From:
To: [DCAdmin](#)
Subject: Comments on planning application 2022/62/92882/W
Date: 29 November 2022 22:28:41

Re. Planning application no. 2022/62/92882/W, 749 New Hey Road

Date: 29/11/22

SITE PLAN

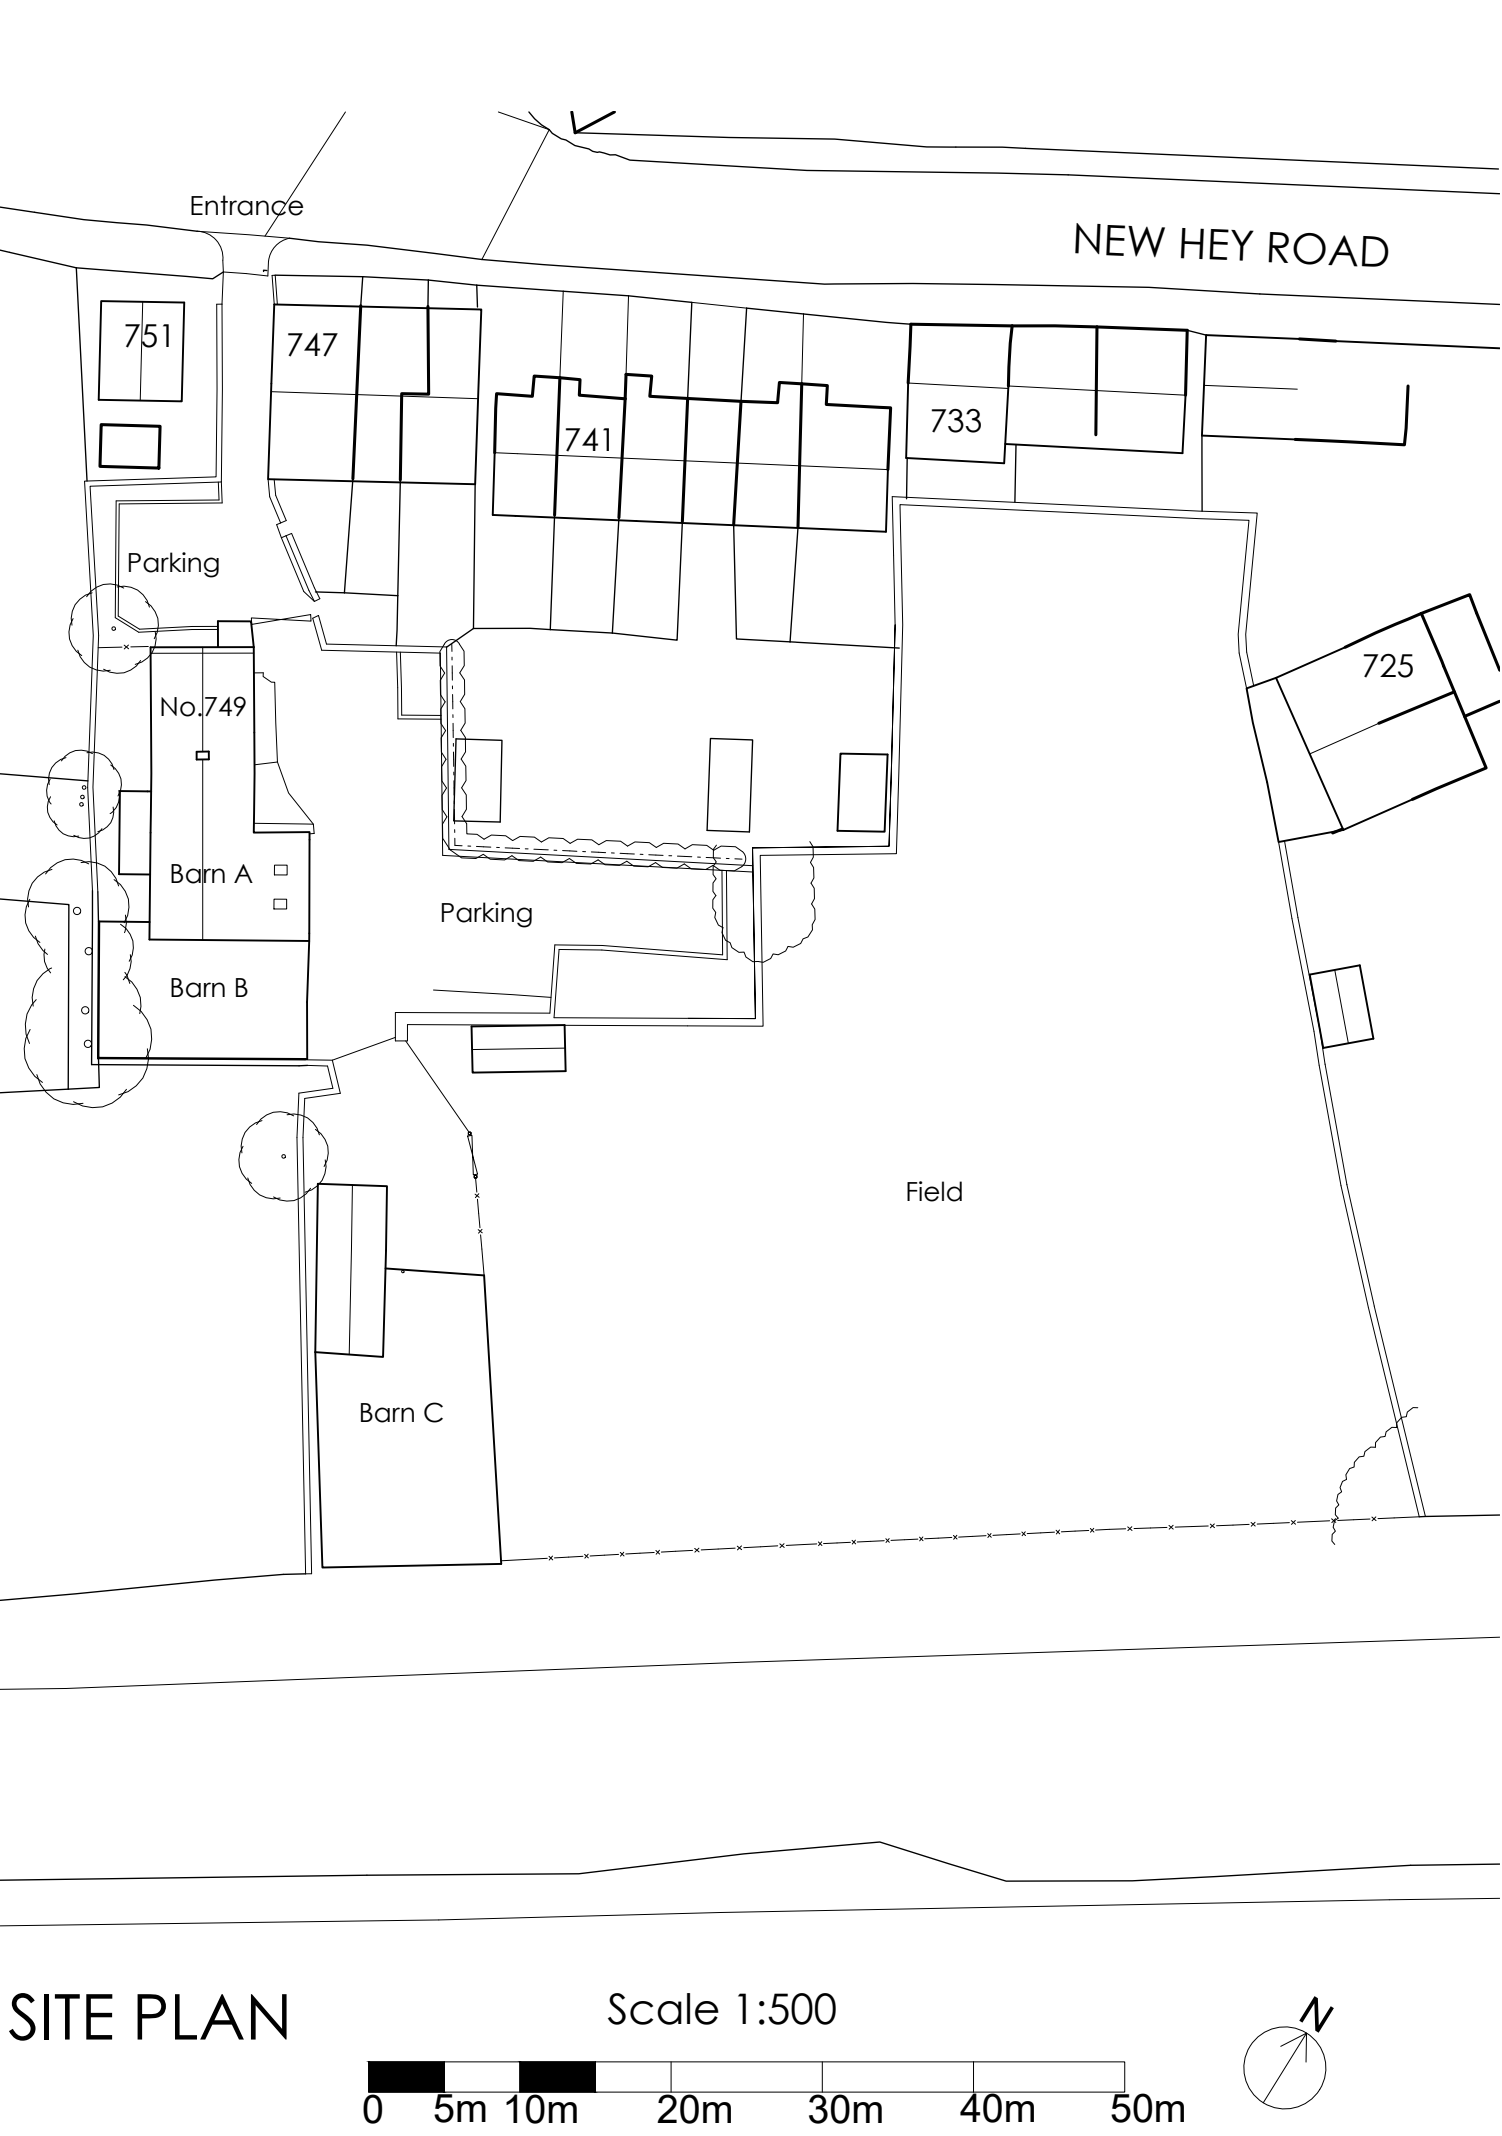
In most of the plans the area behind 751 is shown as 'parking', which is deceptive. Only on a couple of the documents is it shown by an outline boundary that it is not part of the development. That area belongs to me for parking for myself and my visitors. Visitors to 749 will assume they can park there and will be very likely to do so, particularly if the entrance to the new development is gated. Over the years I have had many conflicts with visitors to just one dwelling at 749 parking there or even in the lane, meaning I was either blocked in or out. Increasing the number of residents will increase the frequency of that.

There are three old outhouses below the gardens of 743, 745 and 747 that are not shown on the plan. Whether this is just a simplification or an oversight, the one nearest the lane belongs to me and will be staying there. I do have right of access to the south side of the outhouse, something that is not shown correctly in the current WYK231504 title. I have a copy of an Assent from 24-3-1931 showing it and I will be taking the matter up with the Land Registry. In the Planning Application form PP-11496311 it says there are no trees on or adjacent to the site yet there are several large ones directly adjacent in the hotel car park and a couple of smaller ones on the site itself. I believe there is a cesspit on the site.
